Written Representations in response to applicant's comments on original Representation made by Great Somerford Parish Council. ENO 10168 BR1732.

Drawing no.: 317212/11.7.1

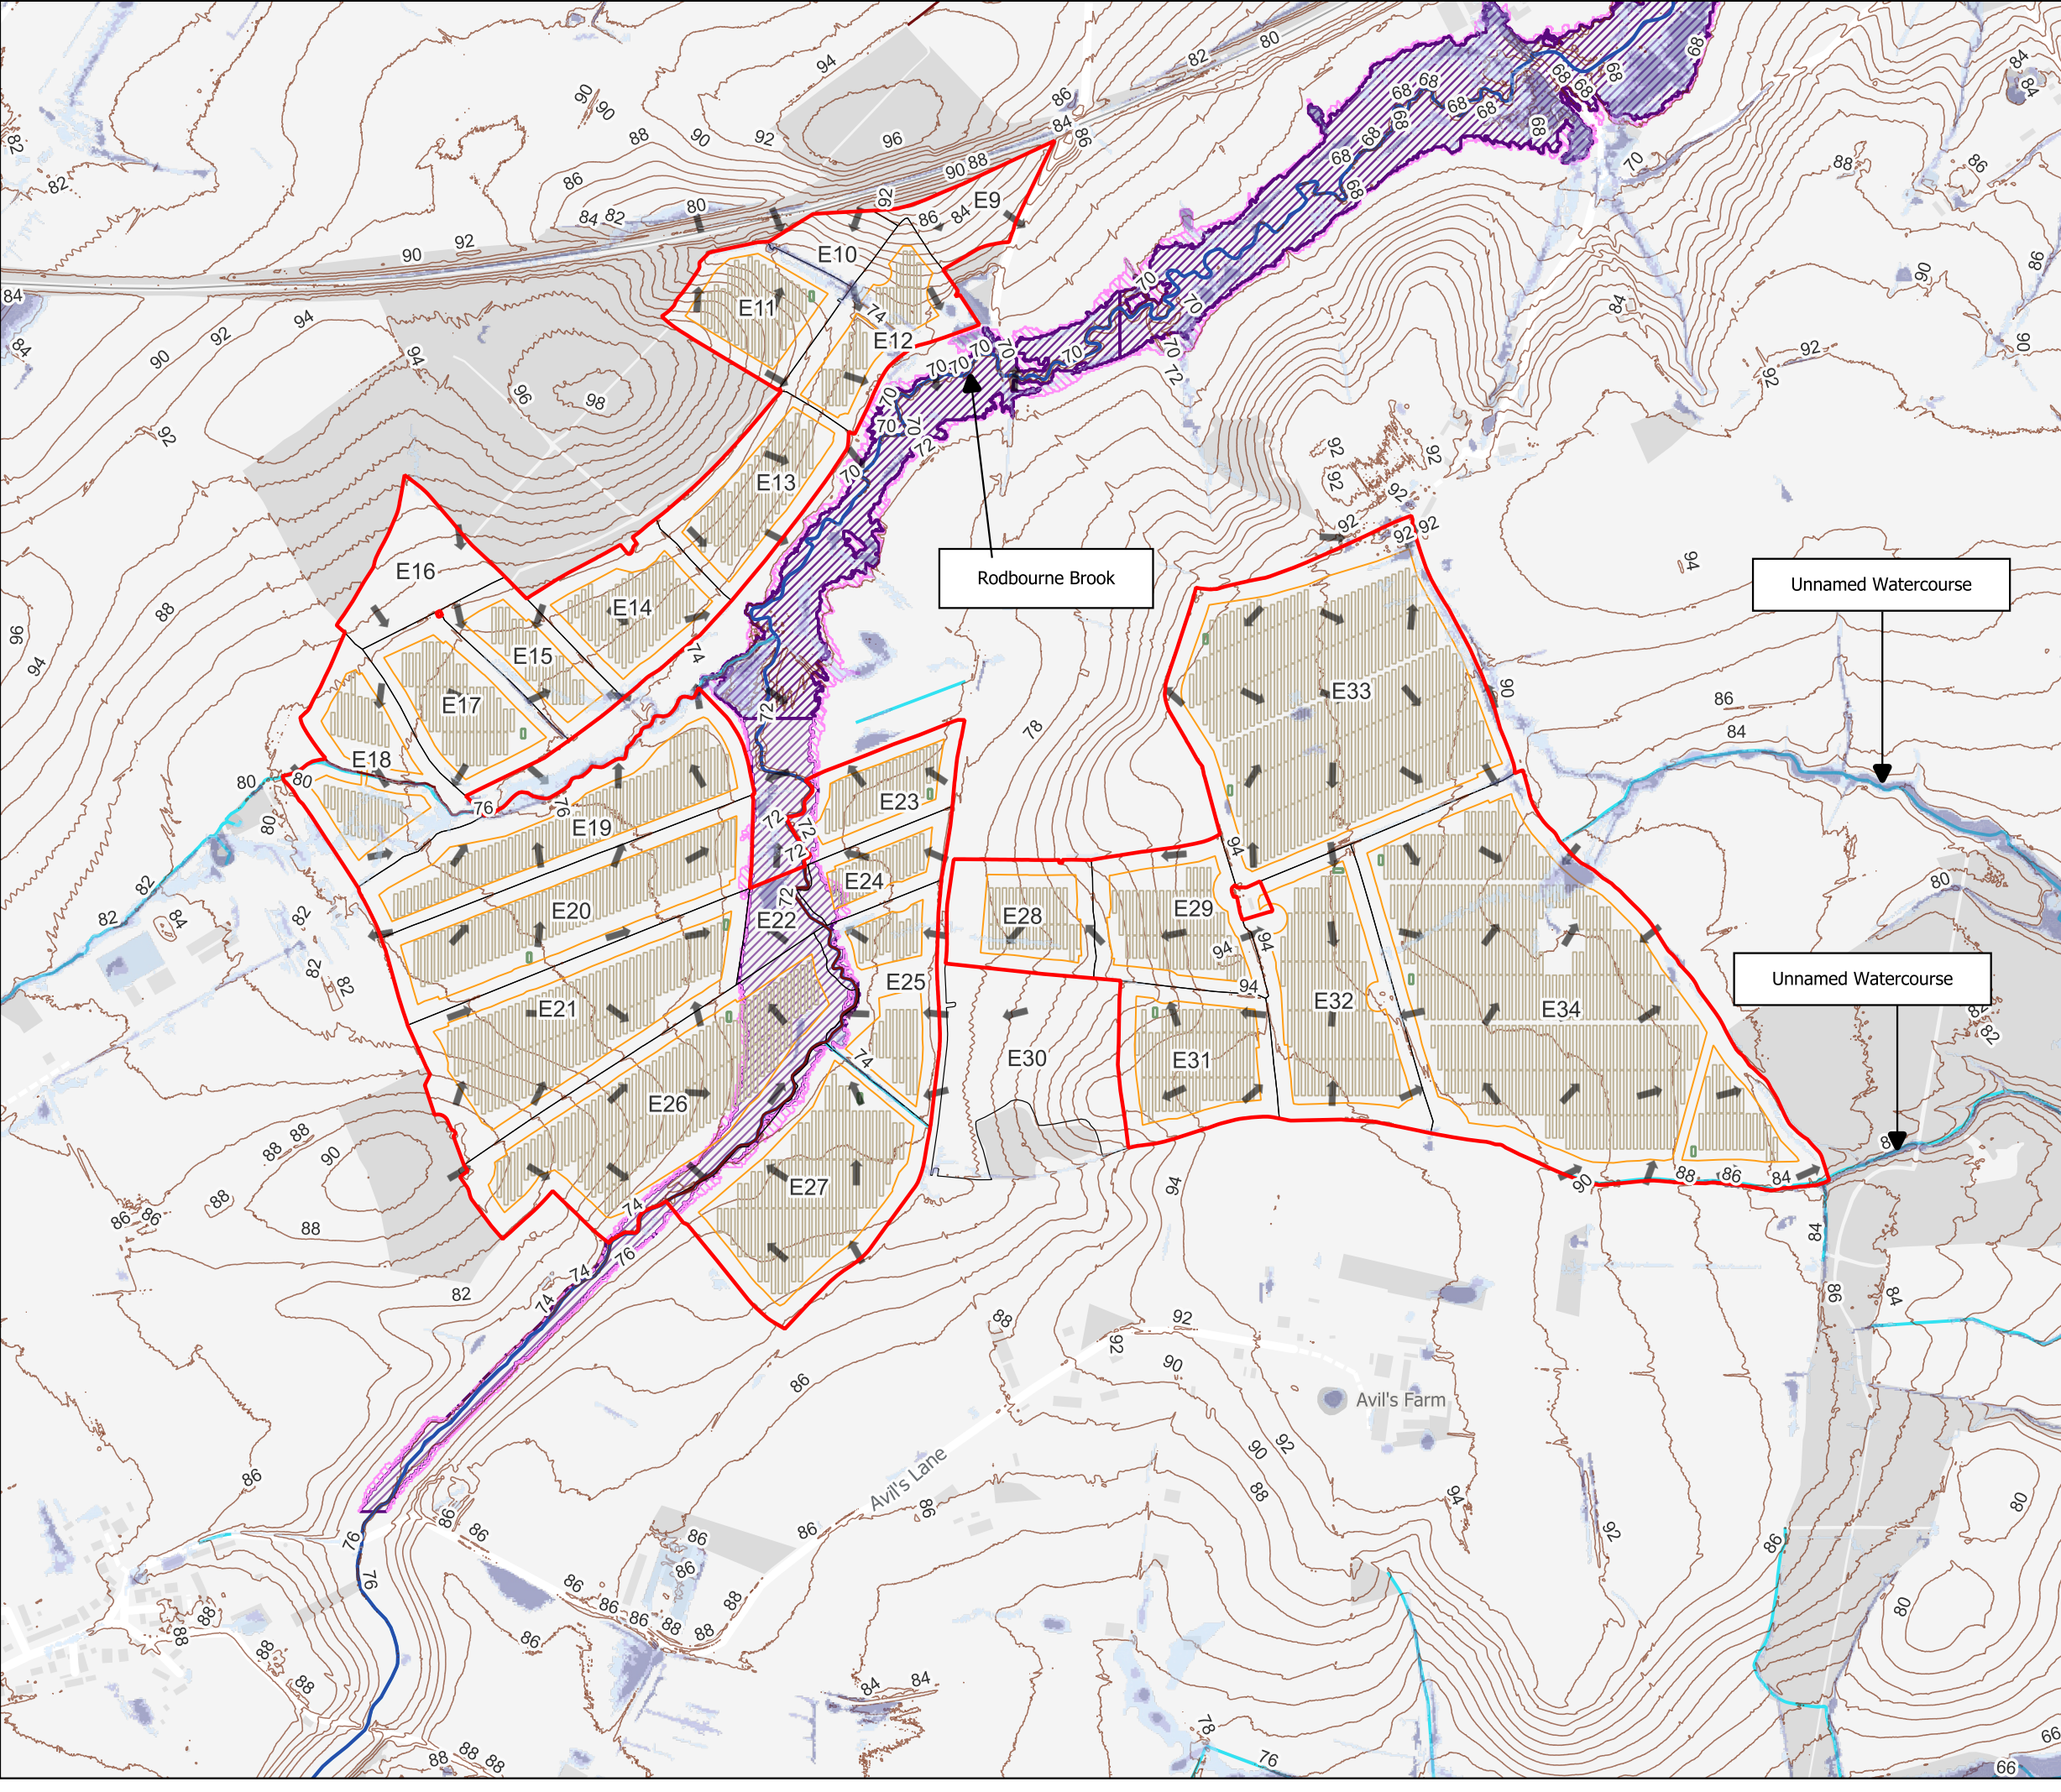
Applicant's response to GSPC-002 refers to displacement from E2. Great Somerford Parish Council has concerns for **all** displacements from the developments, excluding the cable route, as these will increase the flow of the River Avon within the Parish of Great Somerford and the subsequent flood events particularly when the water table is high and the ground is saturated.
